Appeal Decision

Decision date: 10 July 2023

Appeal Ref: APP/R4408/W/22/3310515

Junction of Salisbury Street and Huddersfield Road, Wilthorpe, Barnsley S75 1AH

Title: **150 EXISTING ELEVATION A**

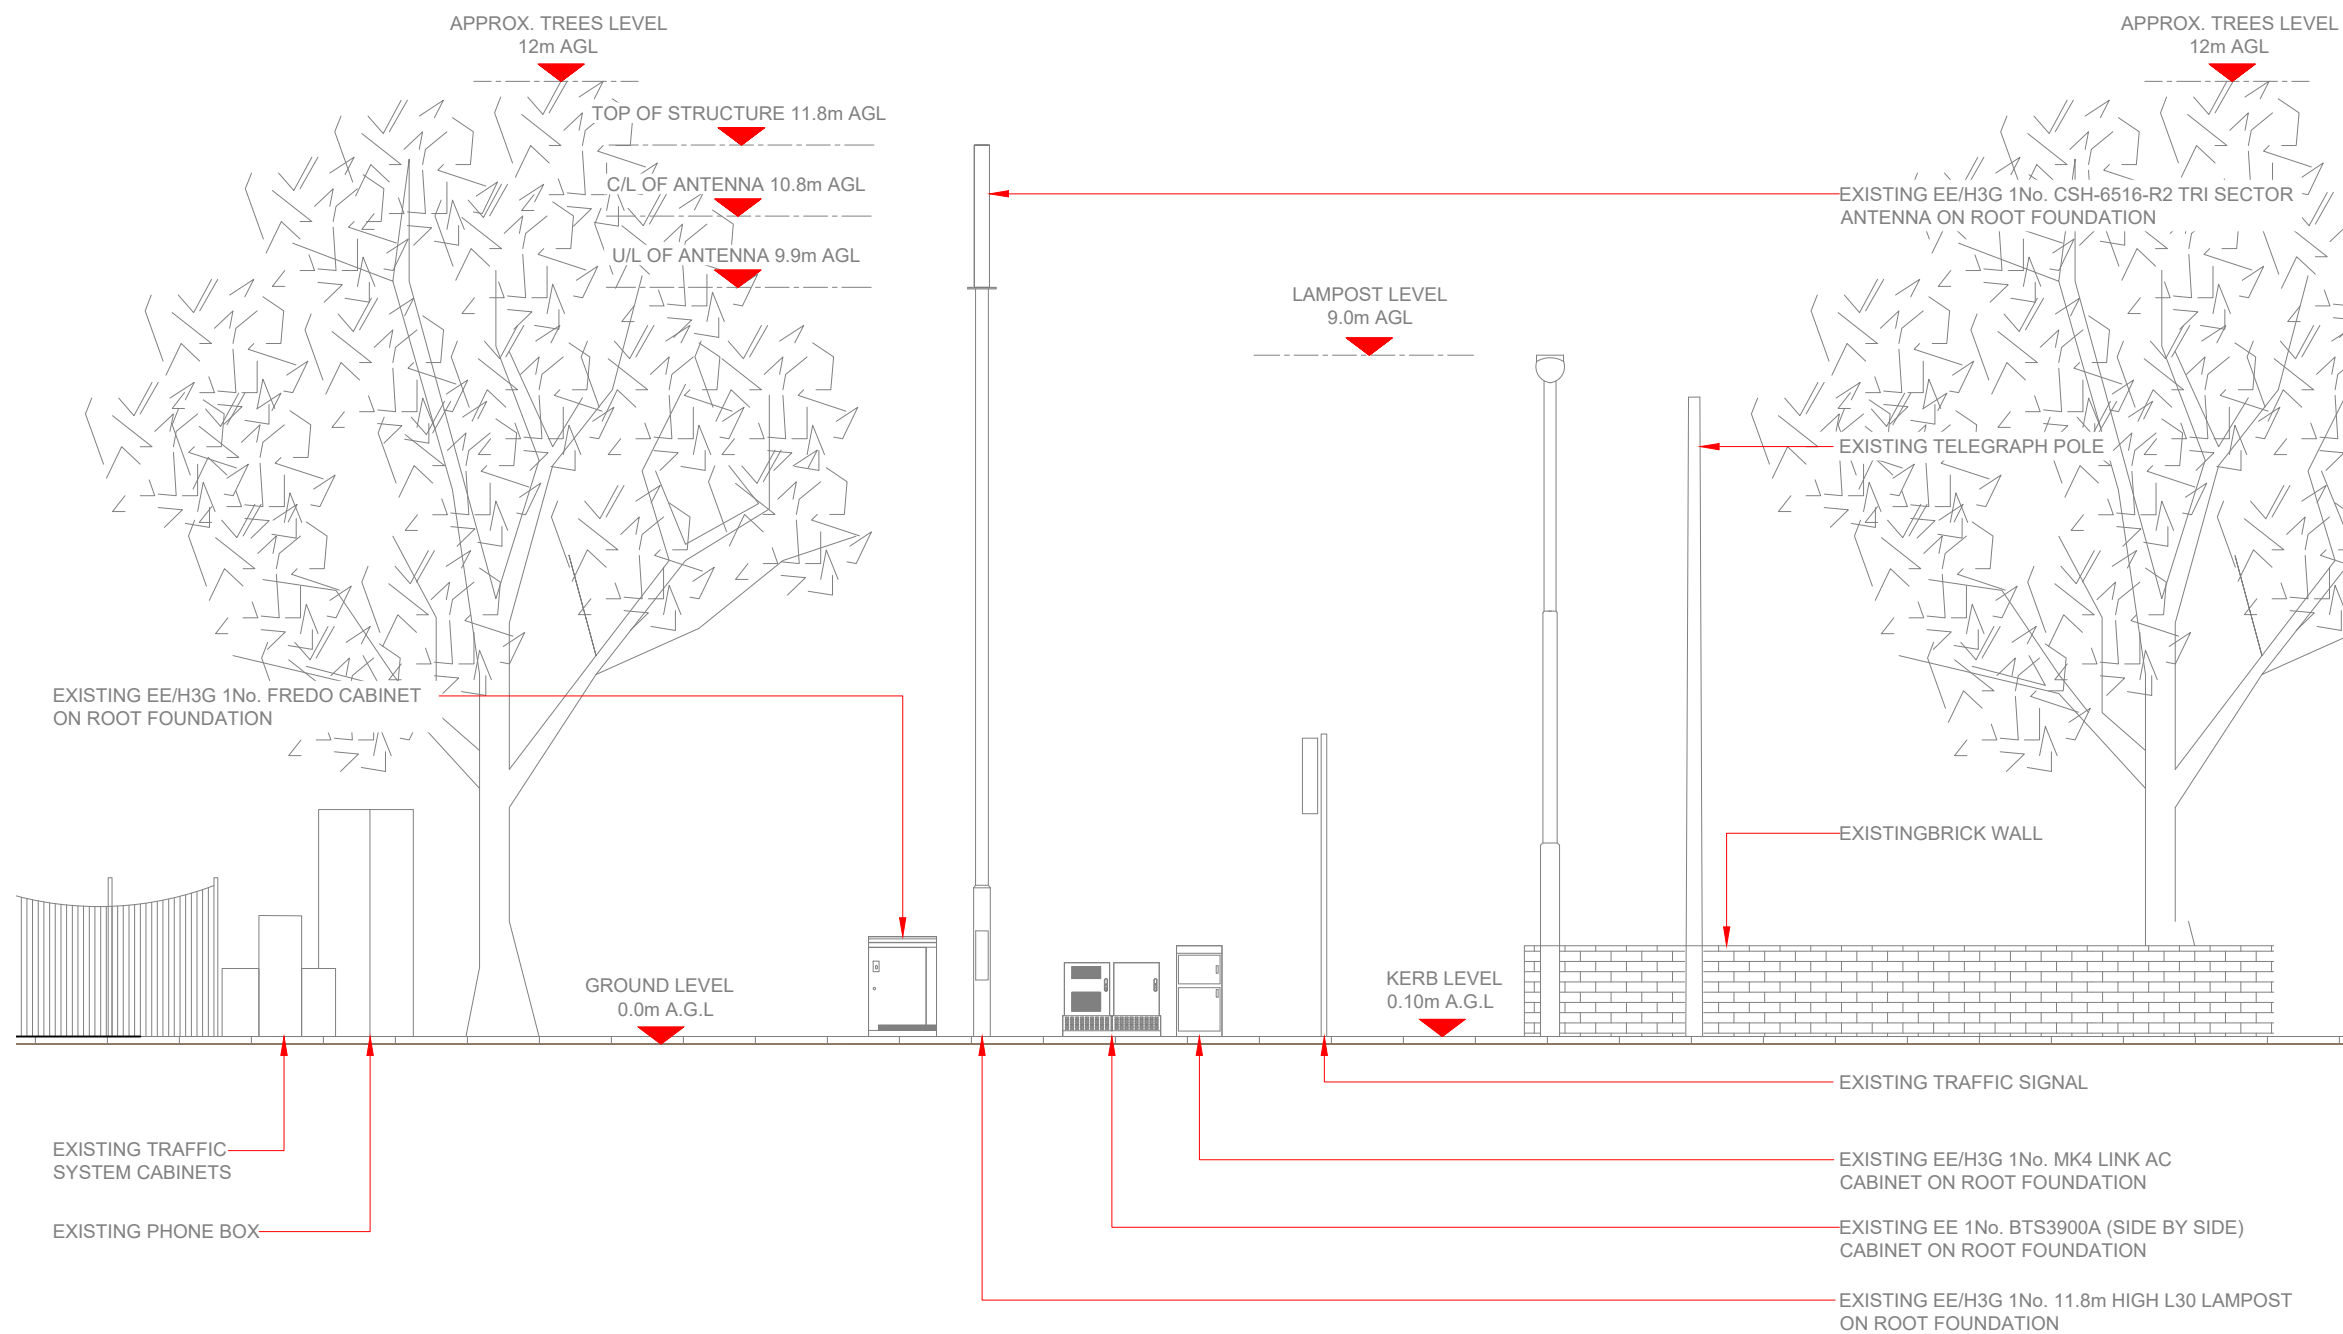
9. The appellant suggests that the existing installation sets a precedent for telecommunications development in this location. However, the appeal scheme is located away from the existing pole, closer to the road and in a more prominent position in the open pavement. Moreover, the appeal scheme would be so markedly different in appearance to the existing mast that it cannot be used as a relevant comparison. It would not be of comparable dimensions and would be appreciably wider and taller than the existing installation that is being replaced by the appeal scheme, resulting in a bulkier appearance.

Title: **265 MAXIMUM CONFIGURATION ELEVATION**

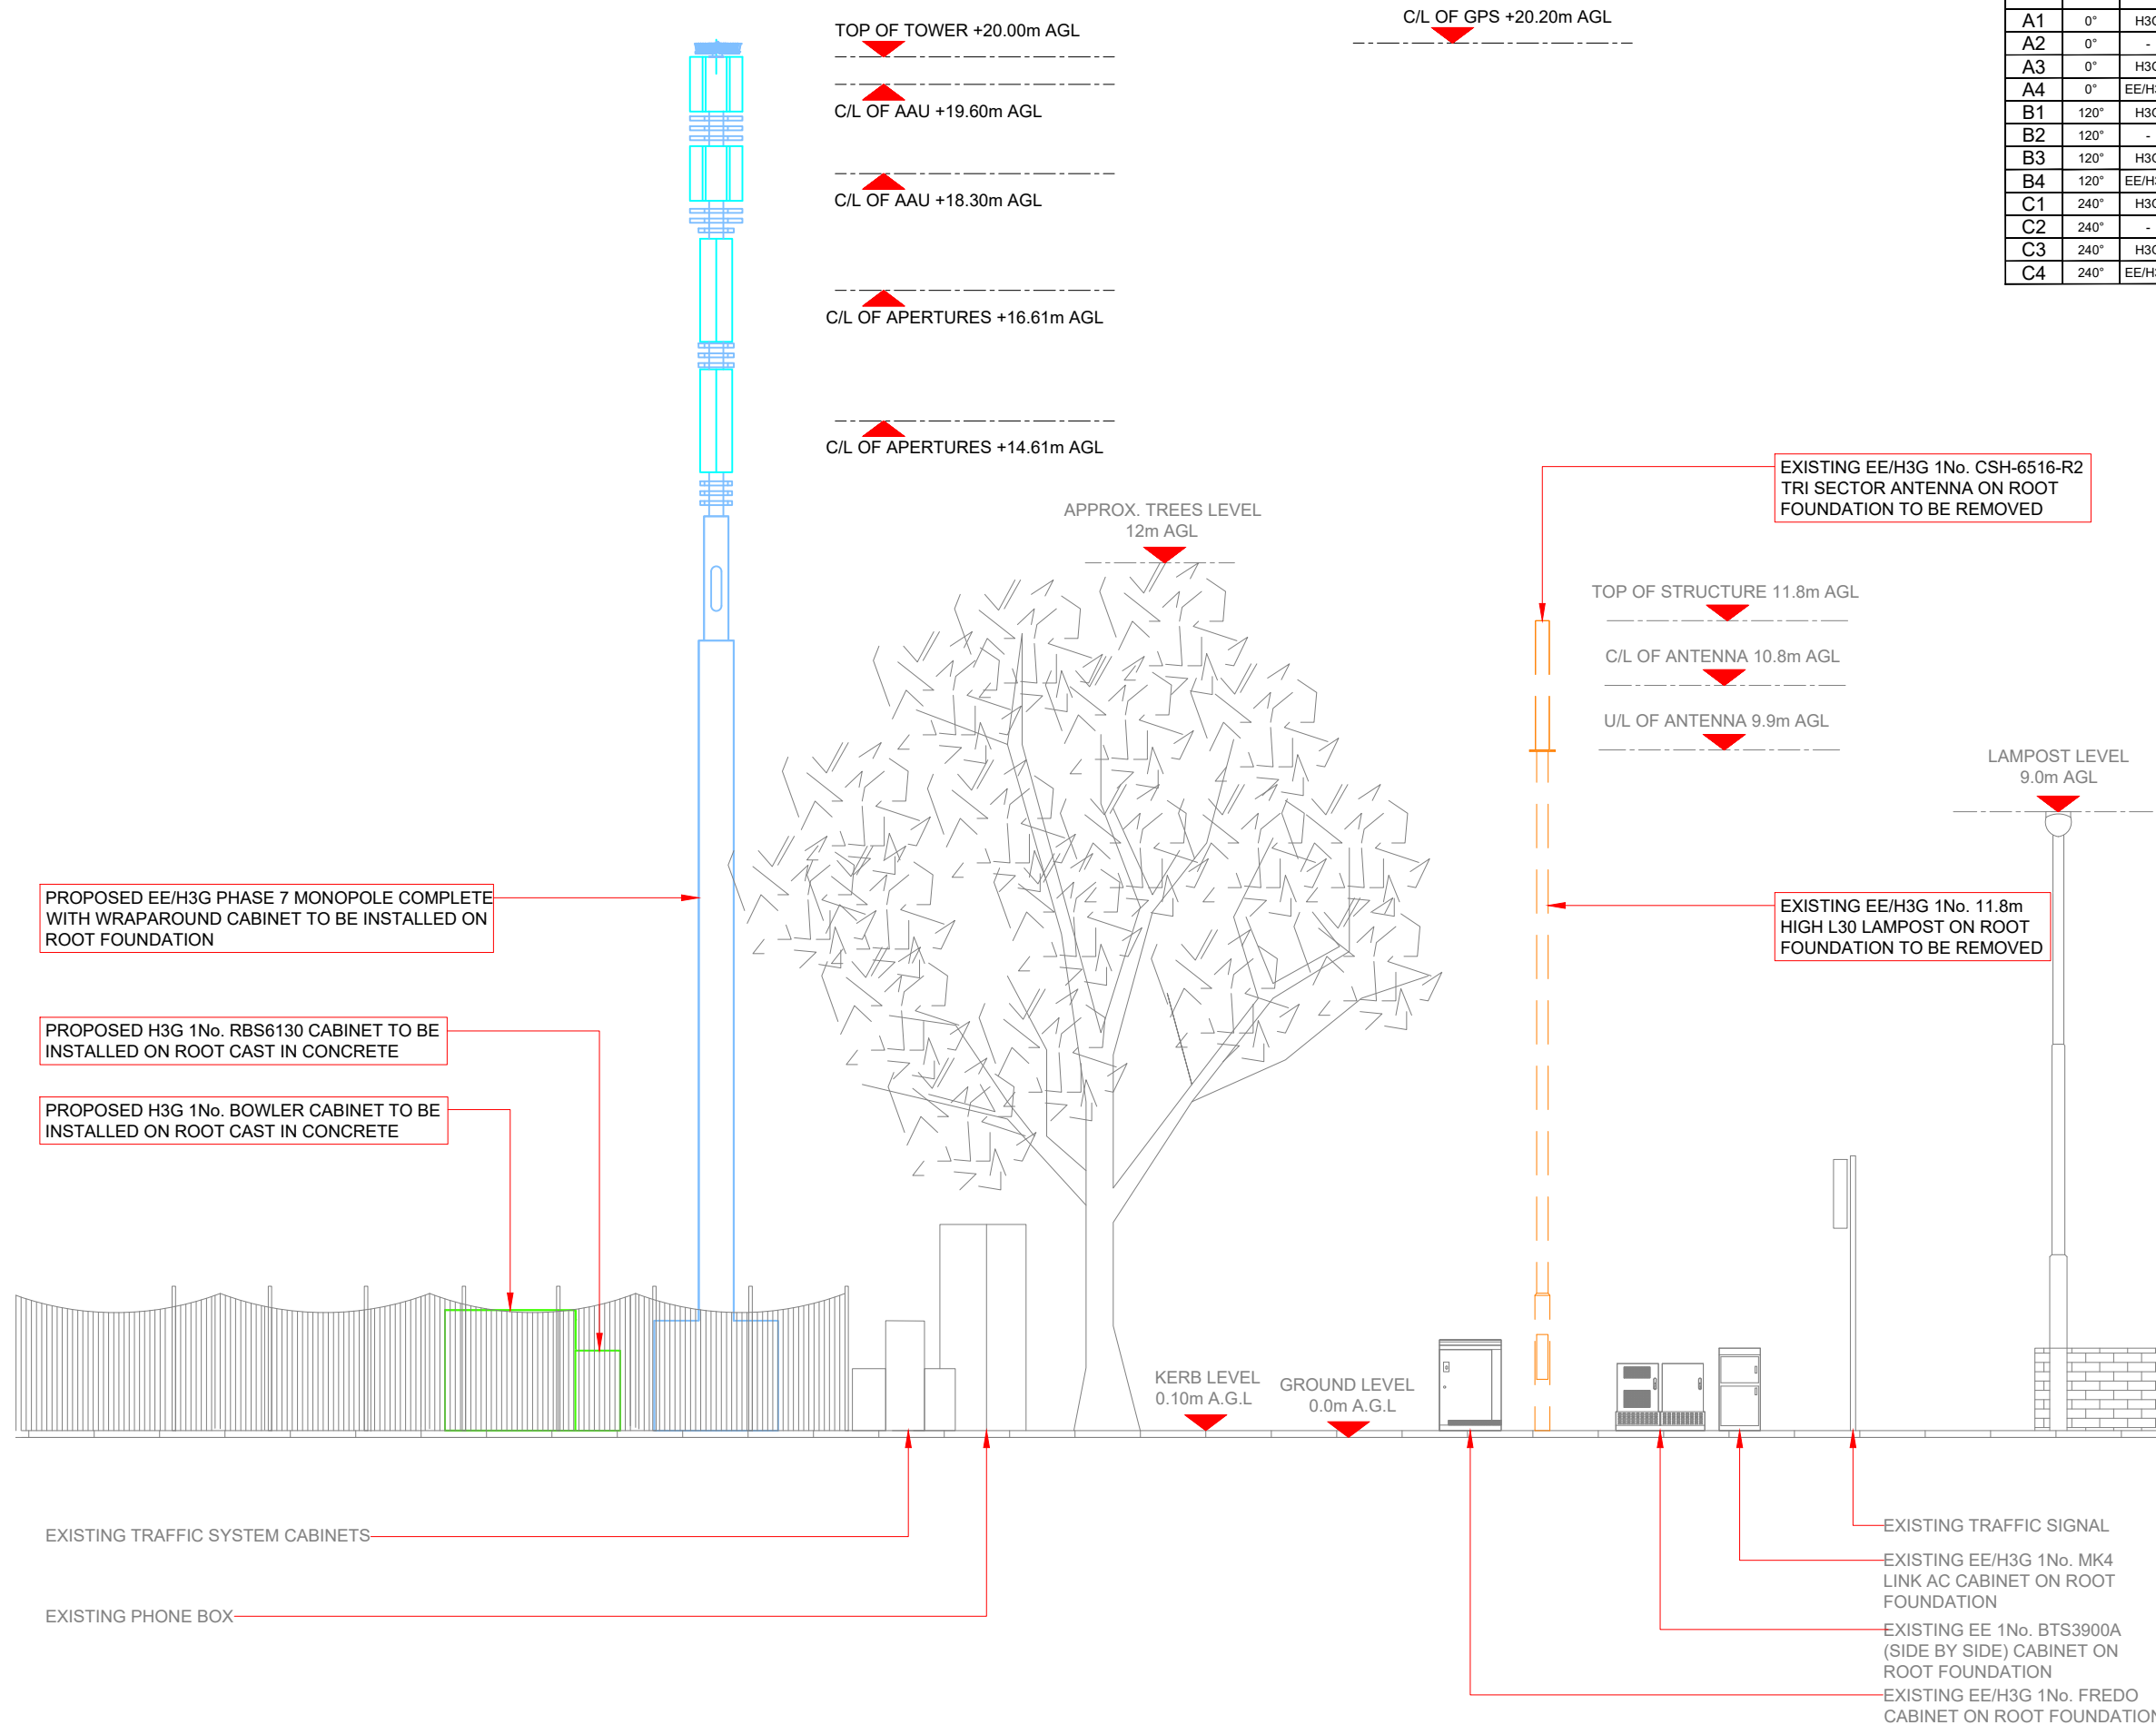
8. The appeal site comprises an area of hardstanding set back from the road. In views of the site from the edge of the HRCA it therefore reads as an area of pavement. The site, and the existing monopole and equipment cabinets makes little contribution to the significance of the HRCA and its setting when viewed amongst existing street furniture and other vertical features. However, while the proposed monopole would occupy only a very small proportion of any views into and out of the HRCA it would, nevertheless, appear significantly taller than other vertical elements nearby. The proposed monopole would be of considerable height at 20 metres to the top of the tower and when approaching the site, it would be a much more conspicuous and intrusive feature in the surrounding area than the existing monopole to be replaced, with a noticeable projection above the nearby trees.

10. While the proposal would be situated in an urban area where monopoles may not be unusual, the appeal scheme would not have a backdrop of commercial units as suggested by the appellant and owing to its height and width would be a utilitarian structure. The entire mast would be visible along Huddersfield Road

and on approach from Hall Balk Lane and Salisbury Terrace. In these views, the proposal would appear jarring against the trees and vegetation which provide a soft backdrop. As such, it would be starkly incongruous and would contrast with the verdant qualities of the locality, including the adjacent HRCA.

11. The appeal proposal's height would appear to be necessary to enable local provision, clear surrounding buildings and trees and meet guidelines for non-ionising radiation protection. However, while it may be that it has been designed to provide the best mobile experience for customers and capacity for sharing, the proposal would nevertheless still be a substantial structure in an open area of pavement.
